Response to Comments Received

Subject: DN02728A - T-Mobile Temporary Tower

PCD File: VA242

T1

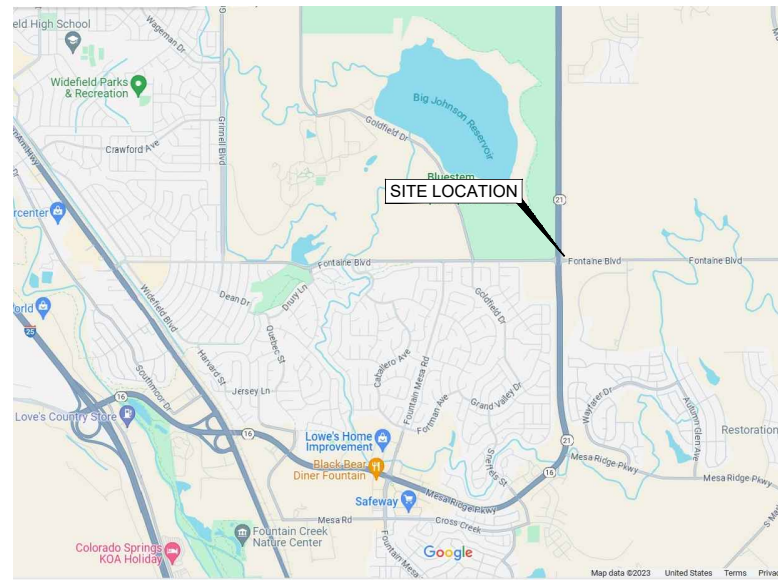
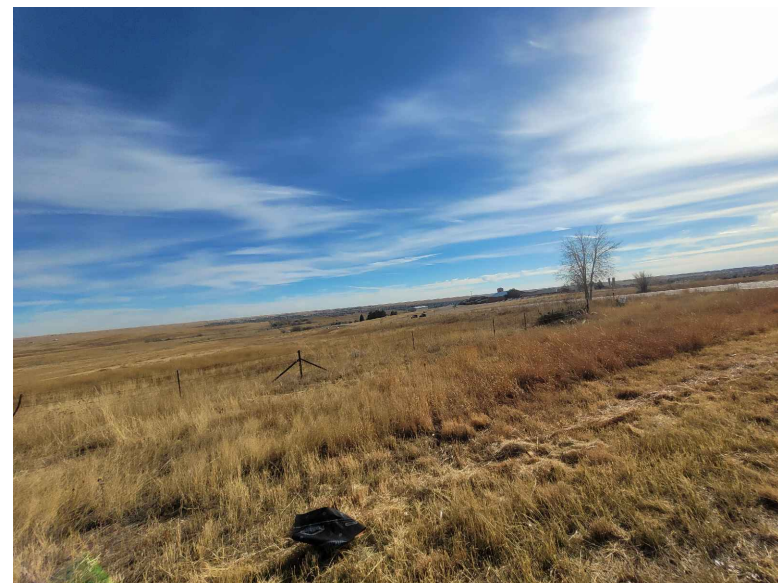
PCD Project Manager Comments: Planning has comments on the following documents: - Application Form - Tower Structure Removal Agreement - Letter of Intent - Site Plan Drawing Joe Letke Planner II 719-520-7964

- Site Plan Drawing: Drawings were updated to add additional information called out in the drawings.
